17 May 2021

File No: 2021/203545
Our Ref: R/2019/6/C
Your Ref: SSD-10340-Mod-1

Fort Street Public School Redevelopment - SSD 10340 Mod 1 - Design and layout changes

/ S4.55- Phase 2 - Drop off Diagram

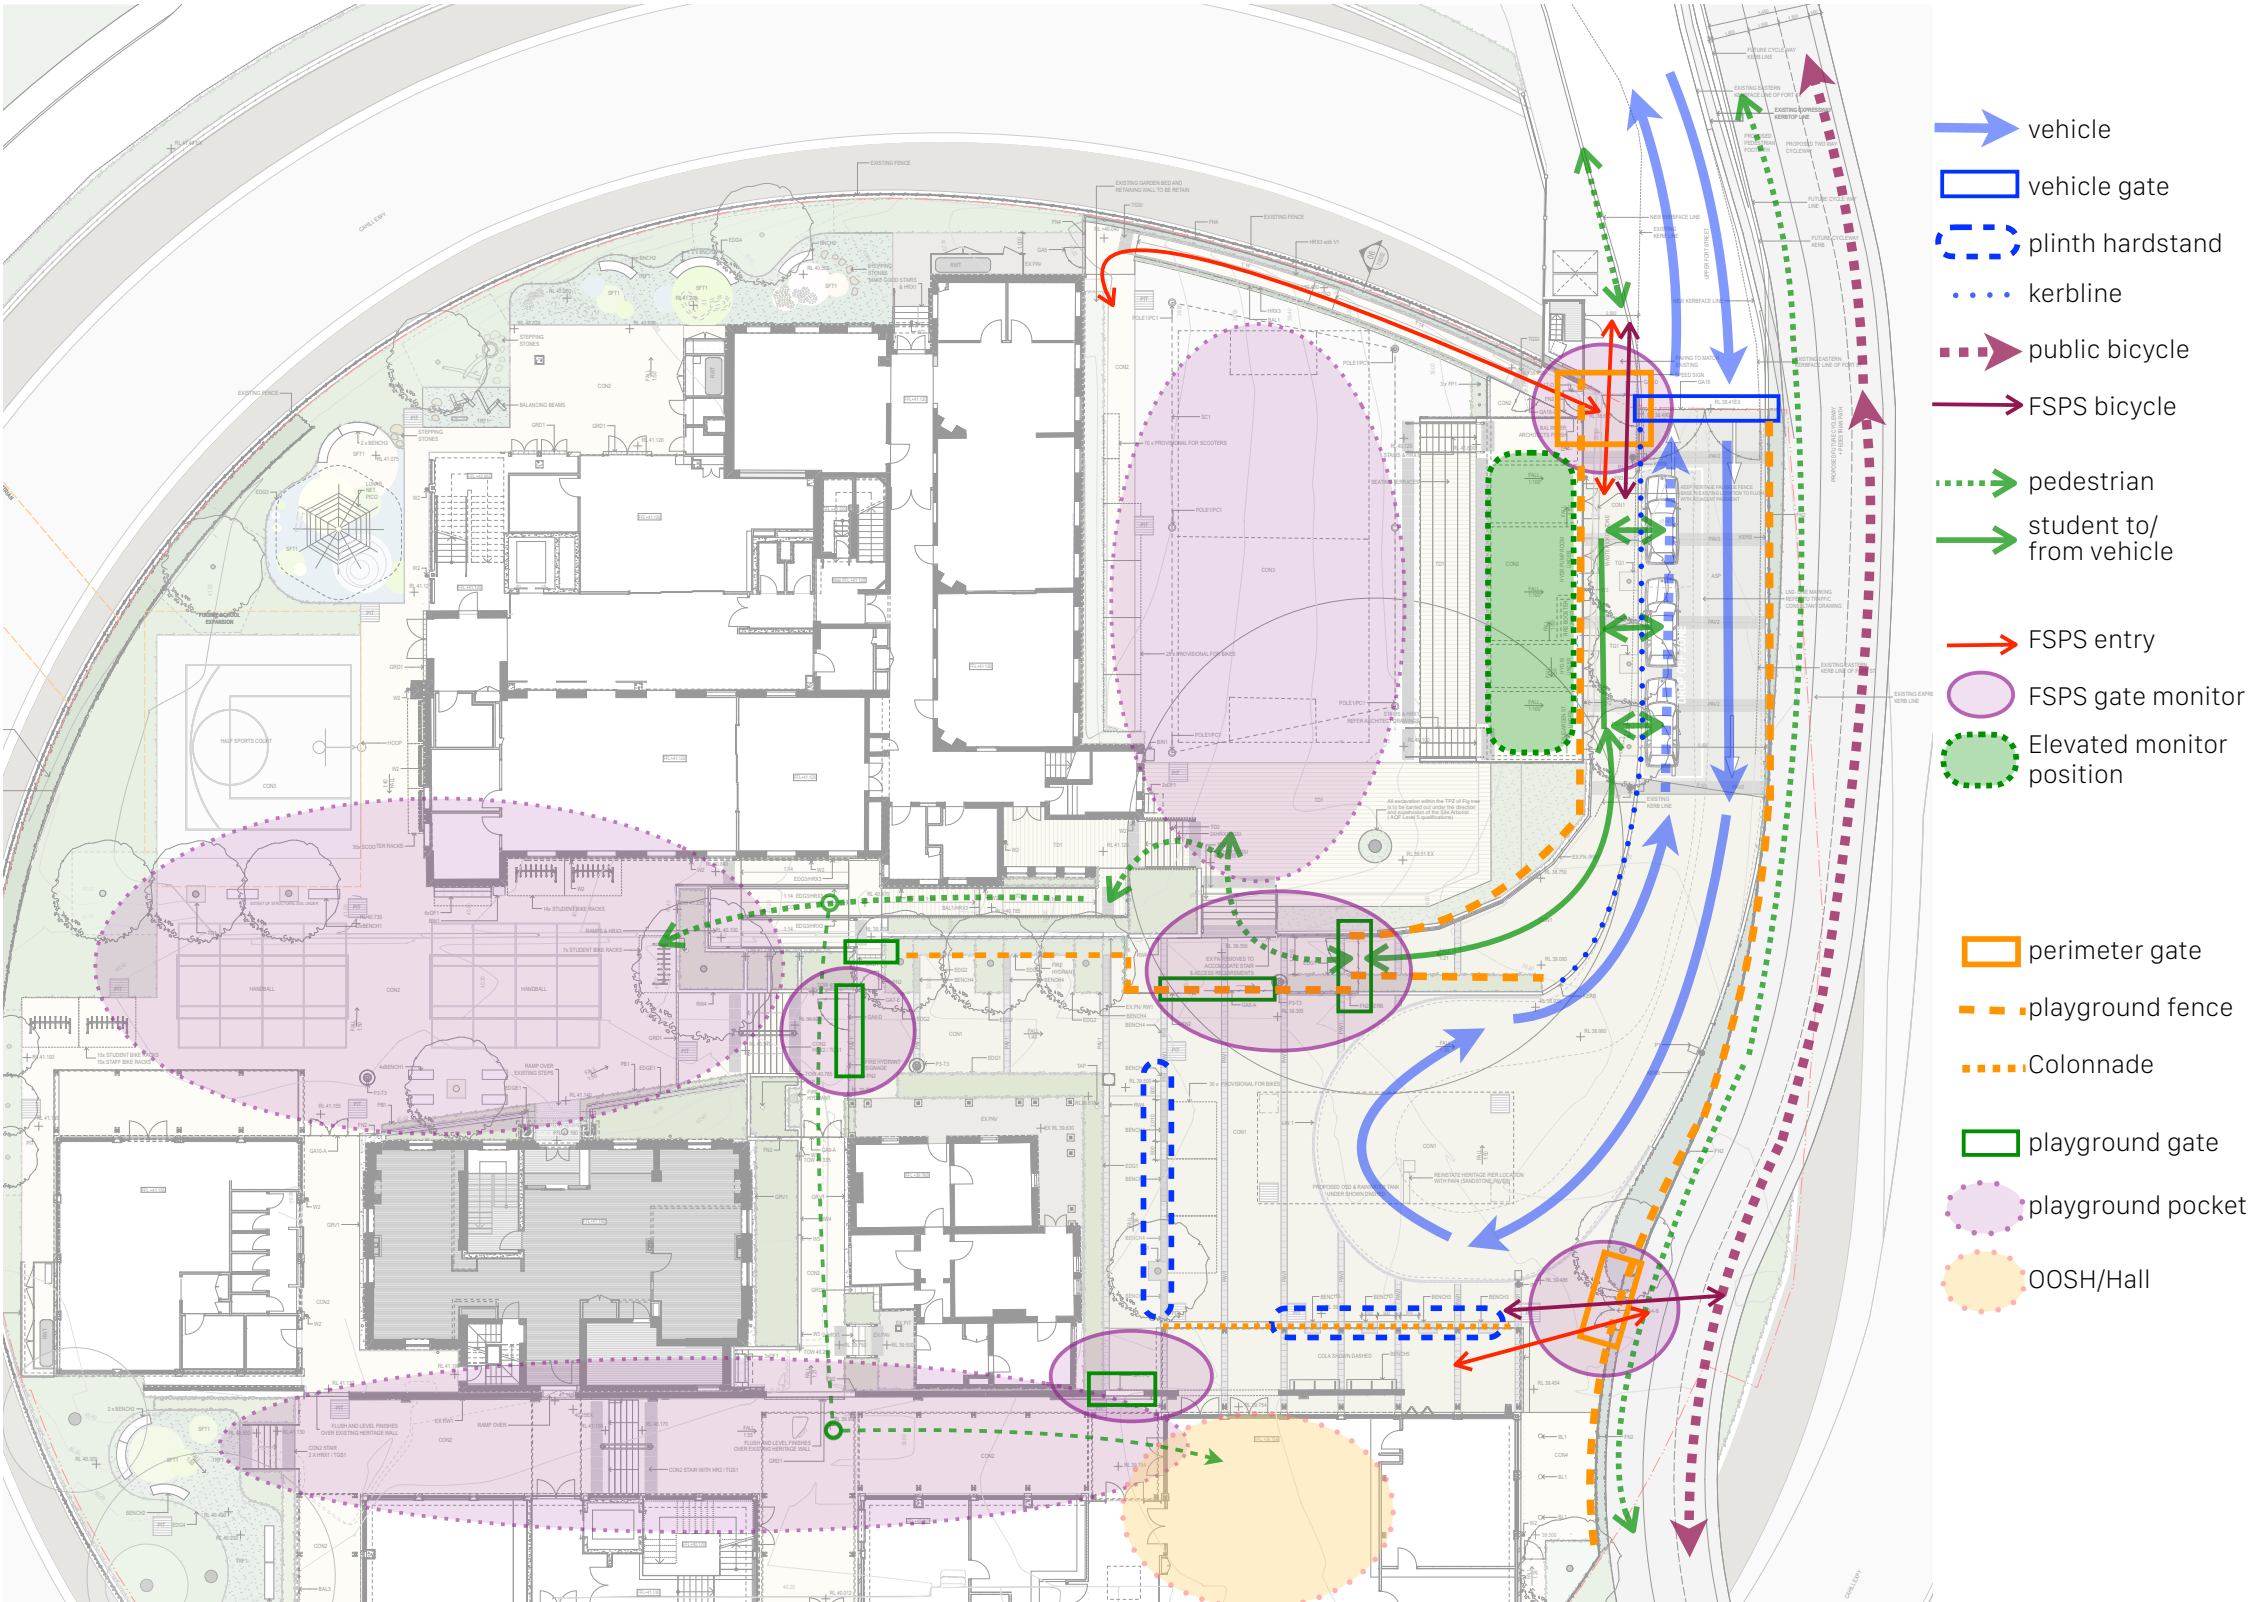
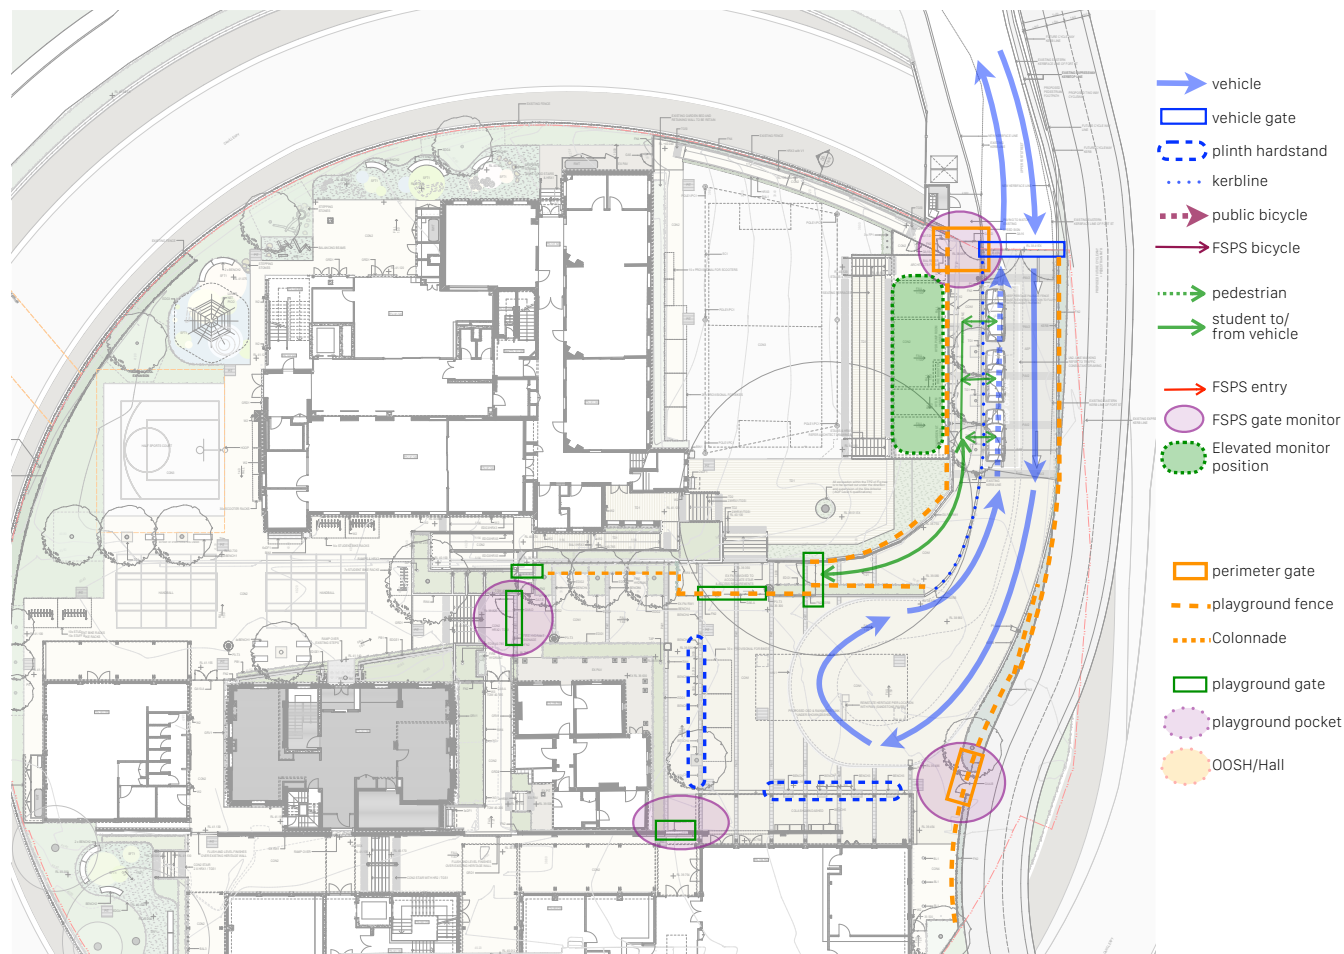
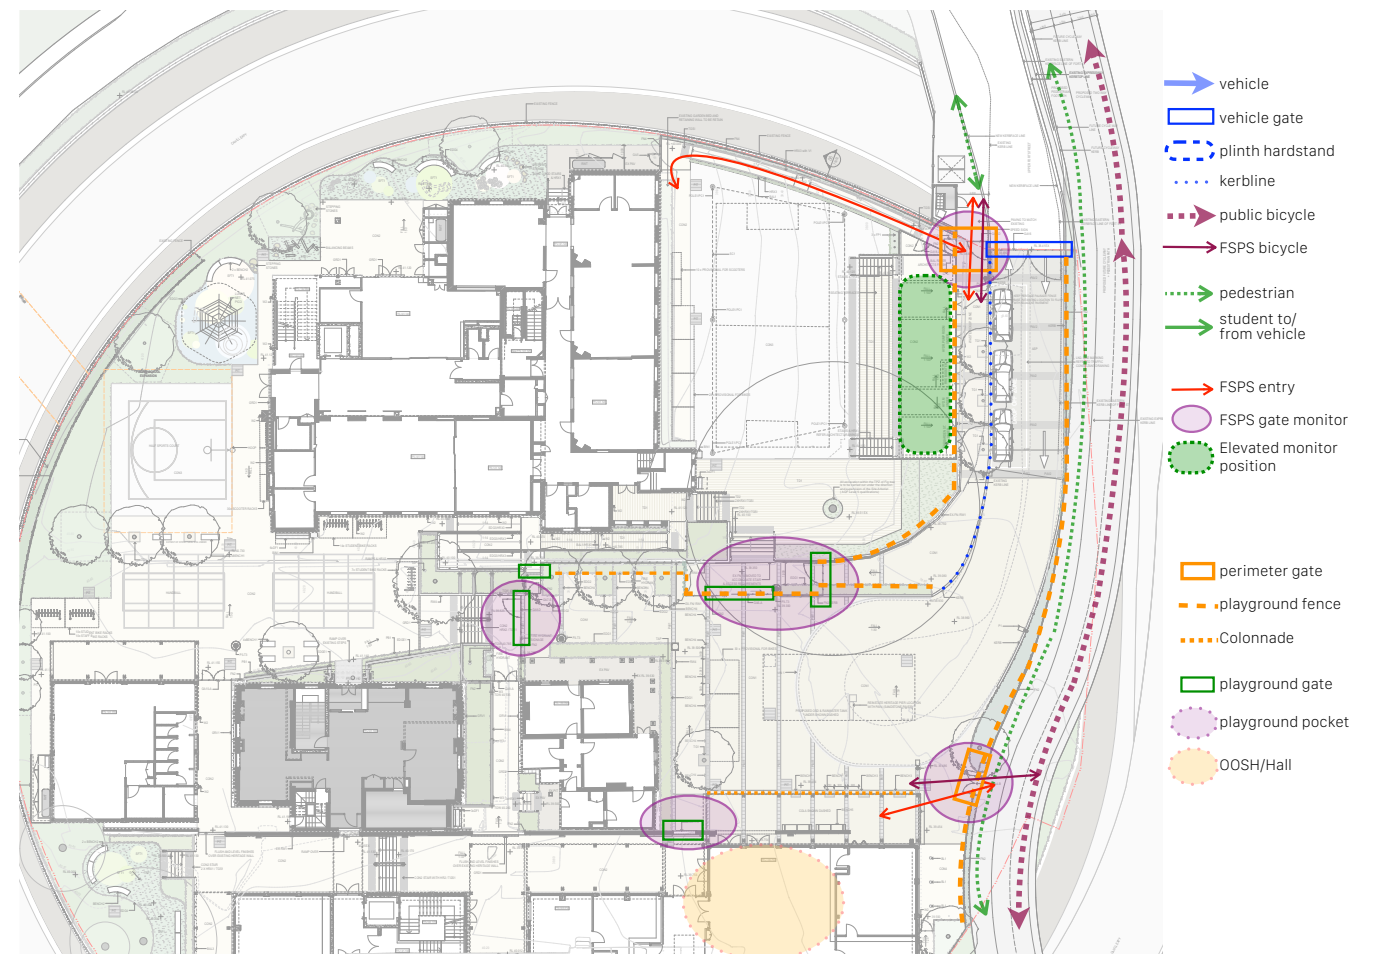
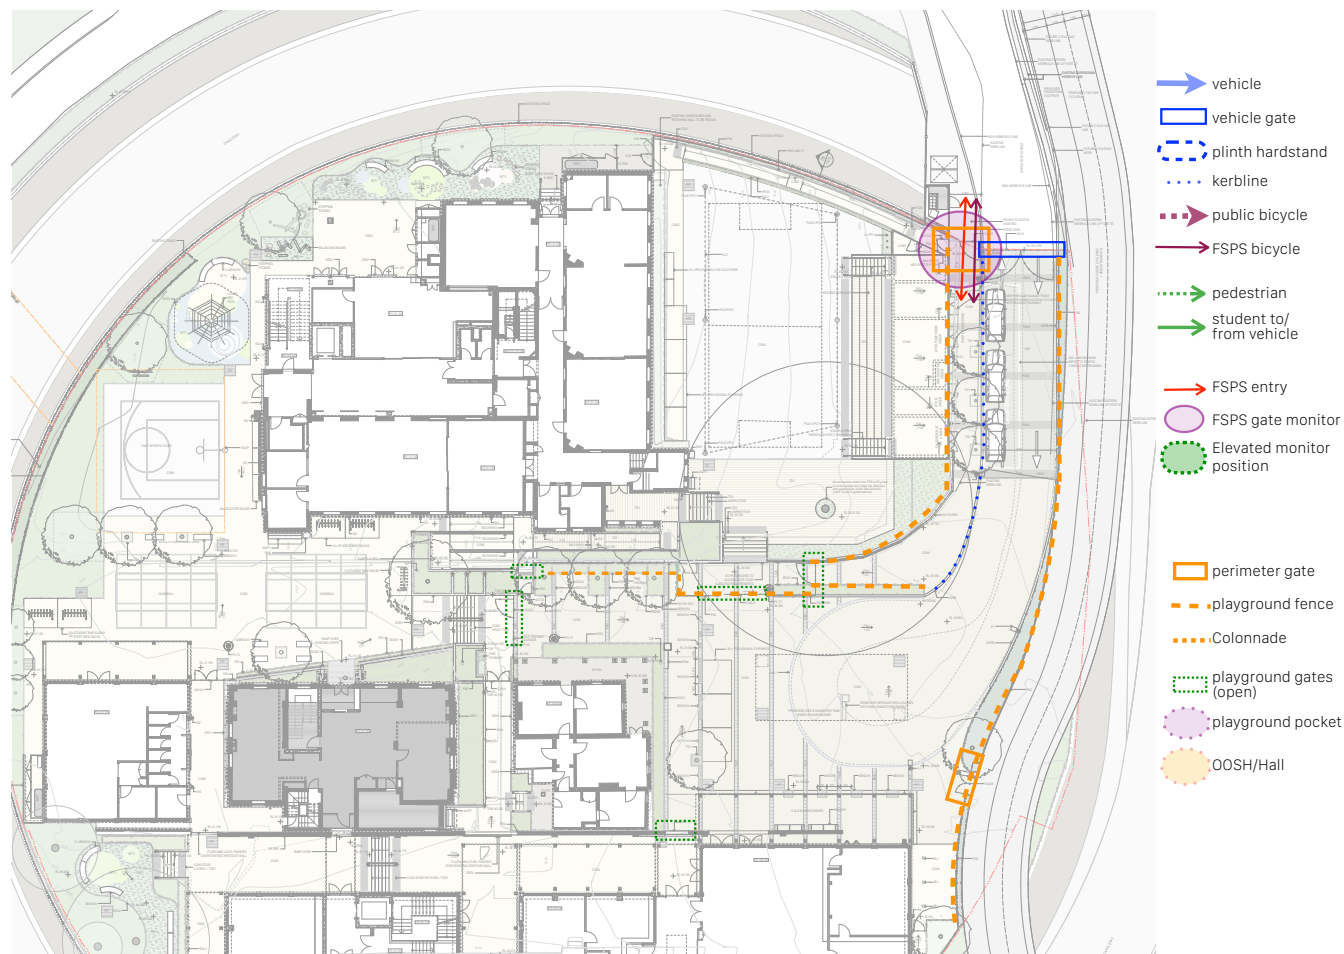
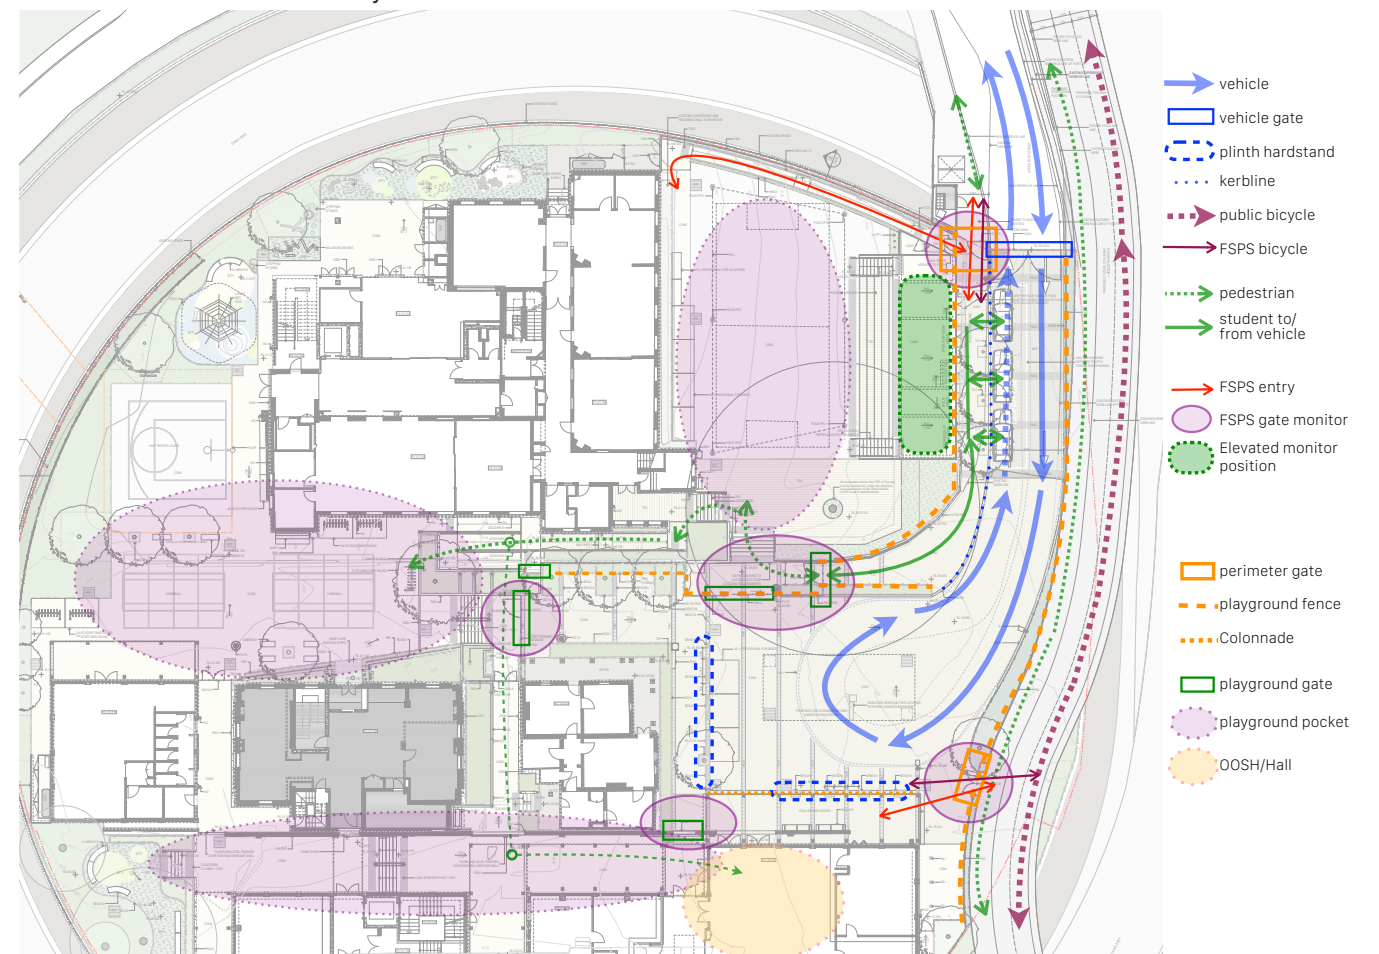
- During Phase 1, there are a lot of cross movements at the proposed pedestrian crossing. The applicant should consider bi-directional cycle crossings on the northern and southern side of the pedestrian crossing.
- During Phase 2, the southern perimeter gate opens directly onto the footpath and cycleway. More space should be provided to allow pedestrians and cyclists access between the school, footpath and cycleway.
- The City notes the proposed turning area of the drop-off/pick-up zone is tight and it is unclear whether there is a physical structure proposed. Confirmation is required that the turning area (drop-off zone) is wide enough for large vehicles (SUVs) to turn.

Current operations use this as a turning area, but many larger vehicles (SUVs) / their drivers cannot make the turn in one, struggling before performing a dangerous 3-point turn and blocking traffic. This is a safety issue when vehicles are reversing or queuing.

The radius of the turning circle is approximately 6.6m. A standard car needs approximately 6.3m to turn safely. Any driver error will lead to the driver being unable to complete the turn in one movement.

- There are currently four metered parking spaces near the school that create a pinch point. It is unclear from the documentation whether these are proposed to

remain (they appear to be marked as main queue). The location of these spaces may compromise drop-off and pick-up movements if cars are parked.
